Council Office Extension Ref: N6/2013/1938/MA

We wish to object to the proposed Council Office Extension on the following grounds.

Title Proposed Materials

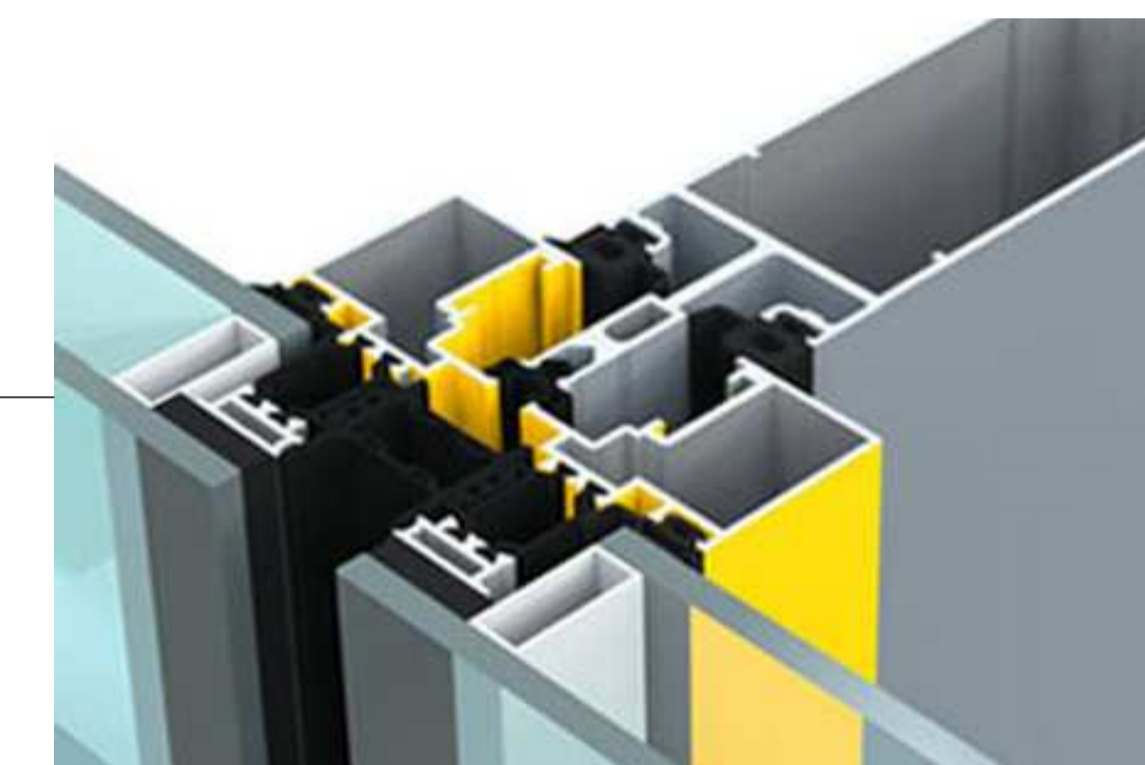
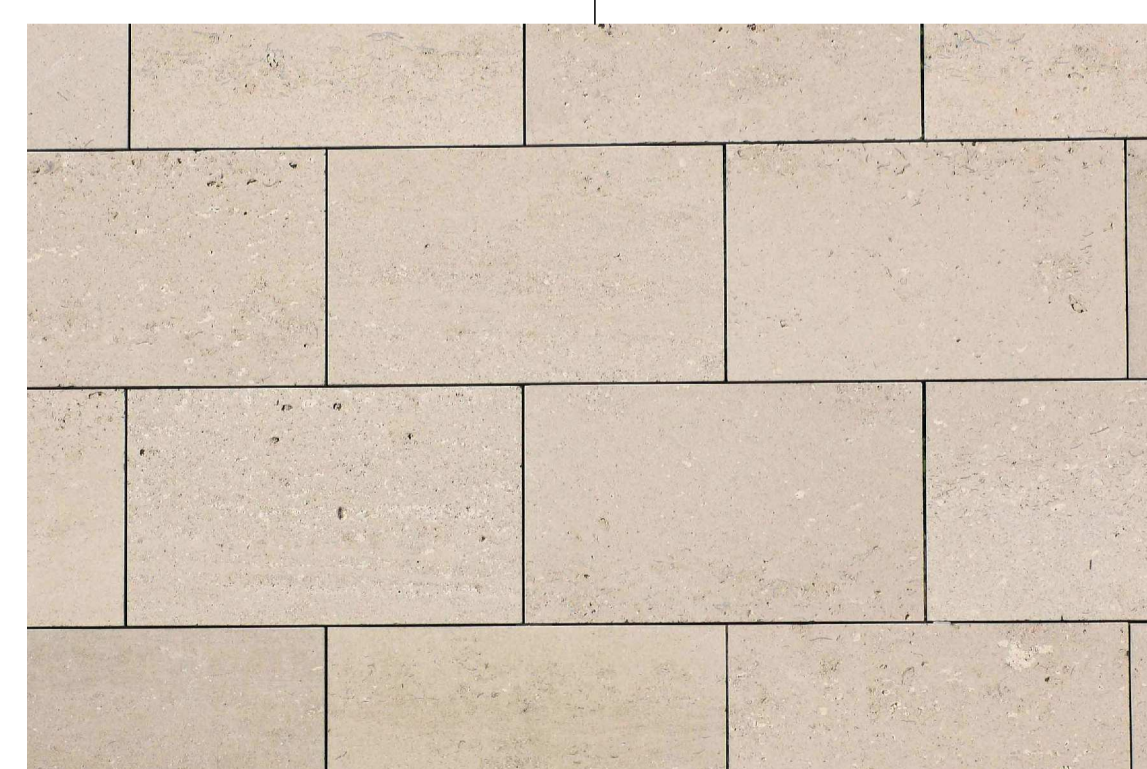
- 2) The angular glass structure is ugly, out of scale and detracts from Cecil Elsom's award winning building. It does not 'respect the materials and setting' nor is it 'subservient to the existing building' which are conditions that the Council impose on all other residents and businesses. The Council should be leading by example, not flouting its own planning rules.
